Jeanette Mose Subdivision

Proposed Zone Change RR-5 & A-5 to RR-2.5

Job No. 201005 Zone Map DATE October 16, 2020

Job No. 211035      **Zone Map**      DATE January 14, 2021

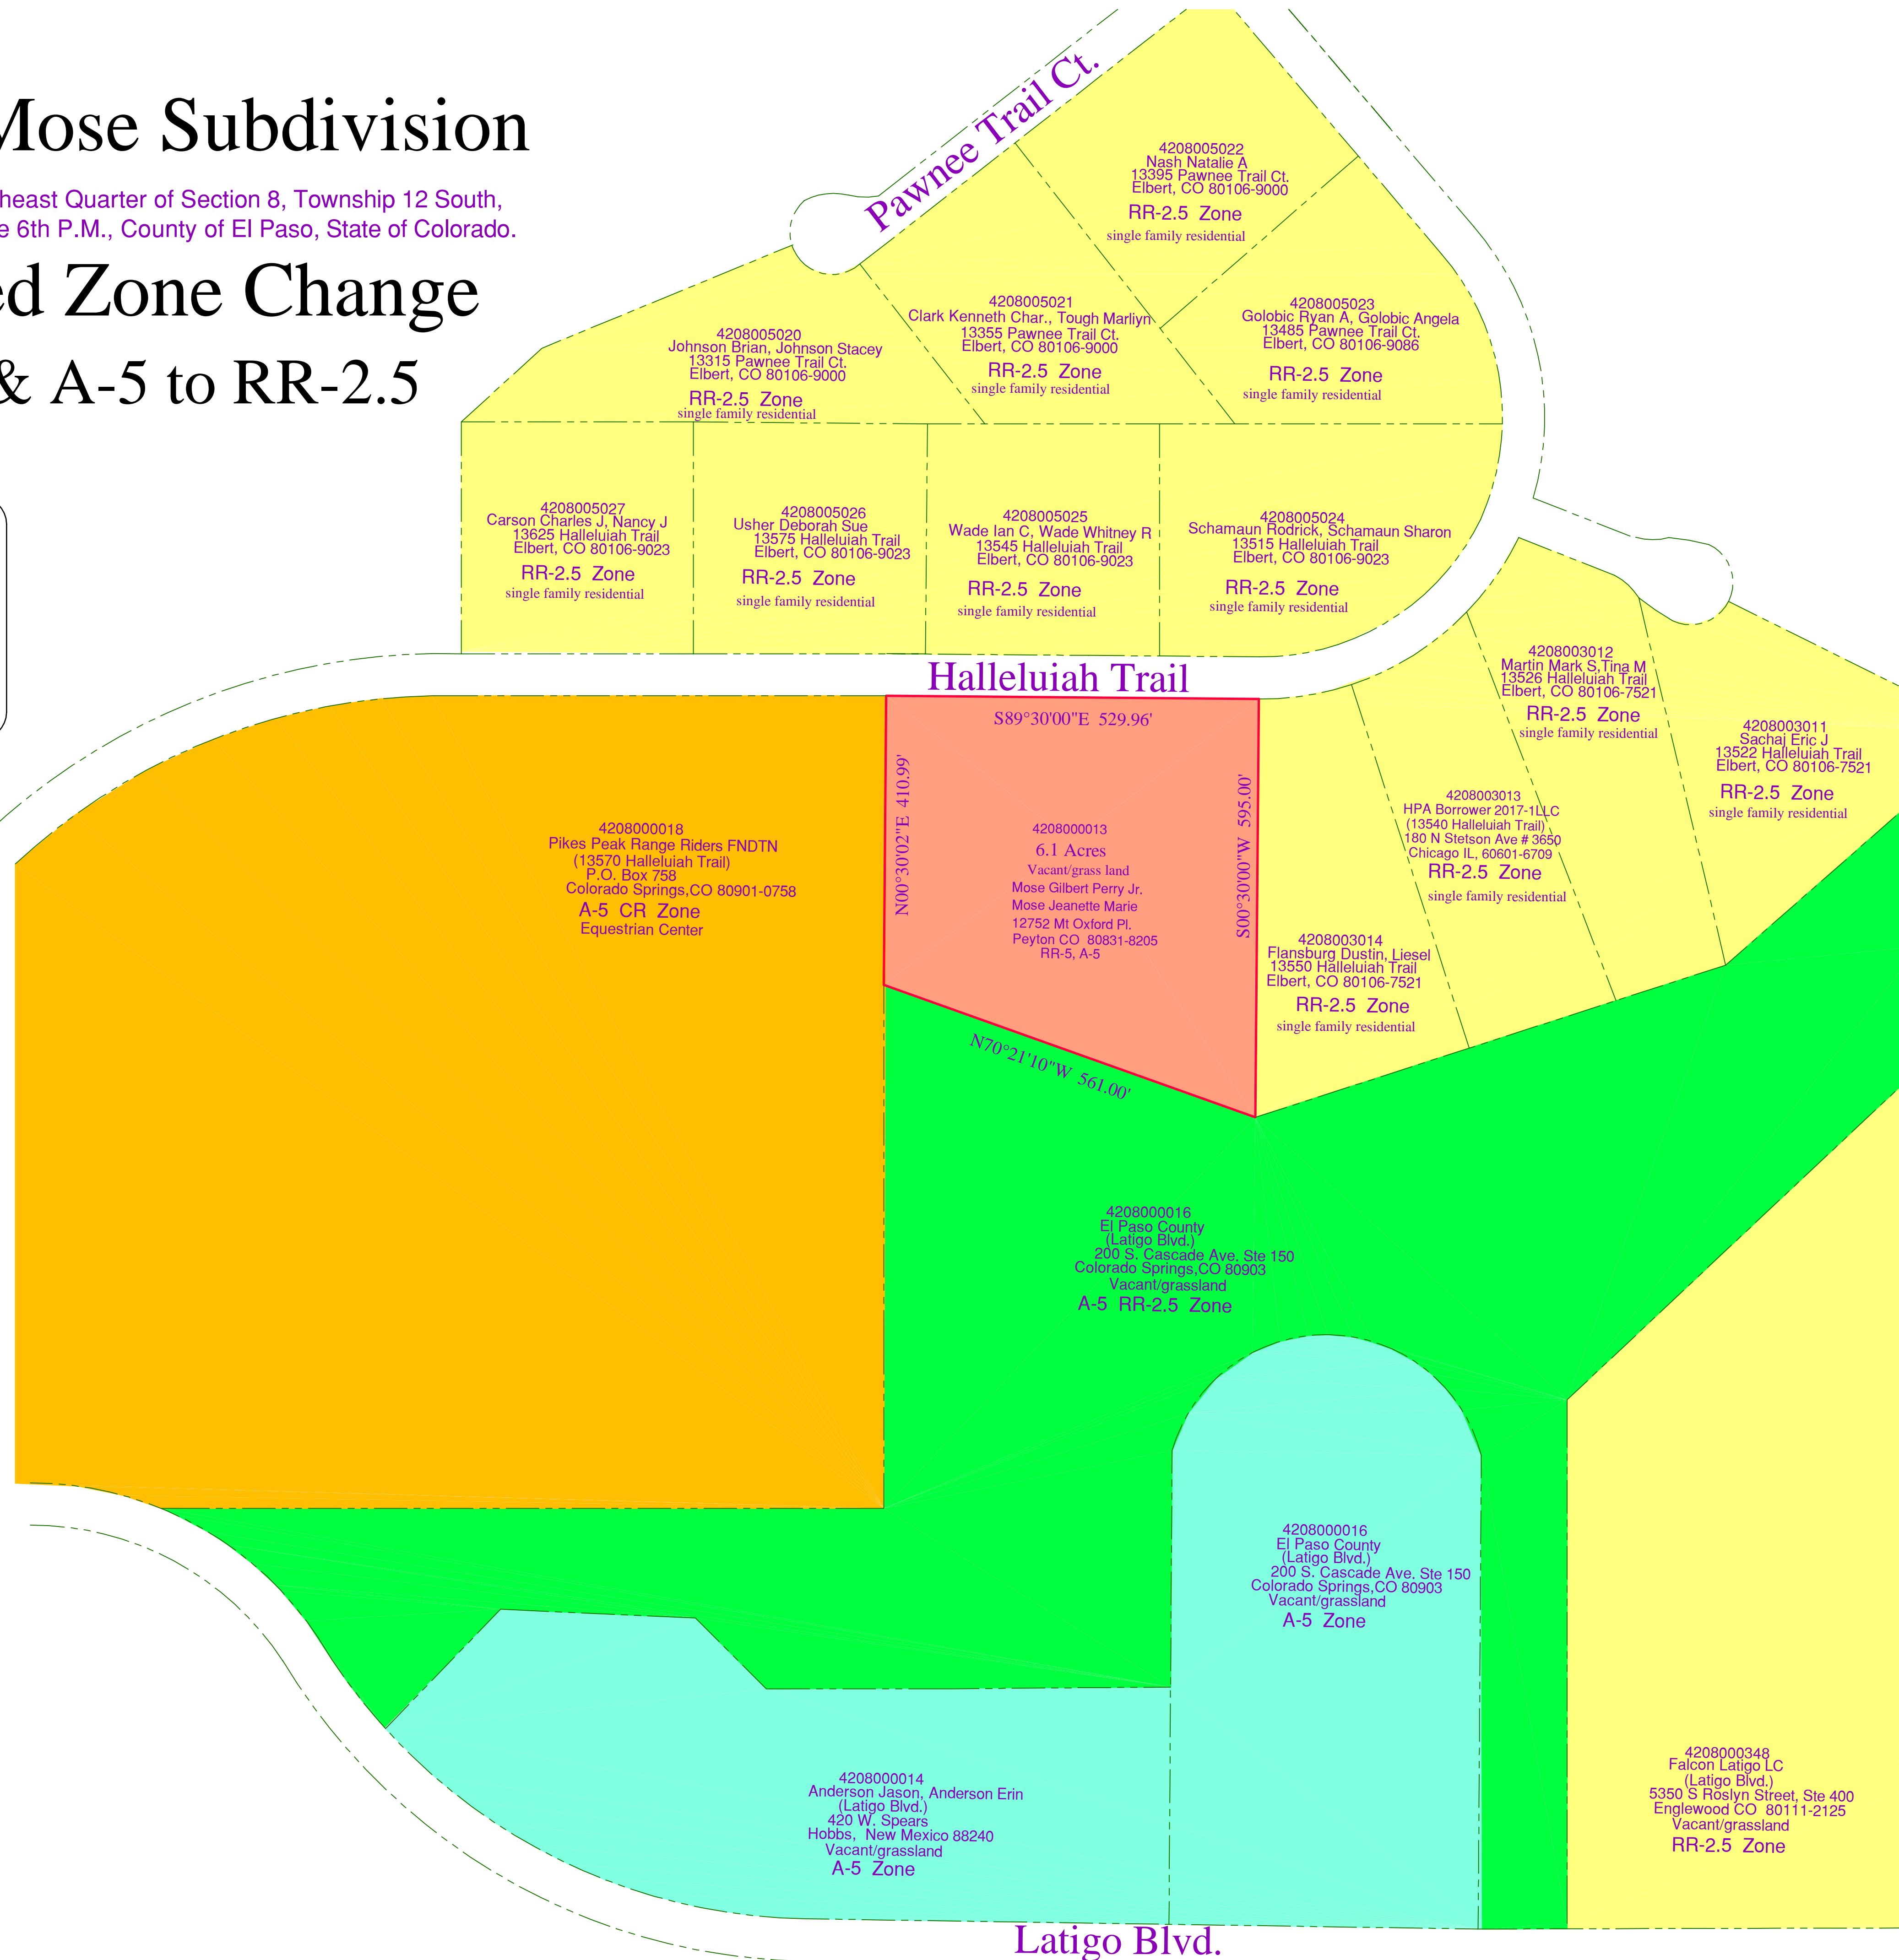
This is not a zoning map. The zoning map needs to show the existing zoning designations of the subject property, as well as show the zoning of adjacent properties and the surrounding neighborhood. Revise and resubmit.
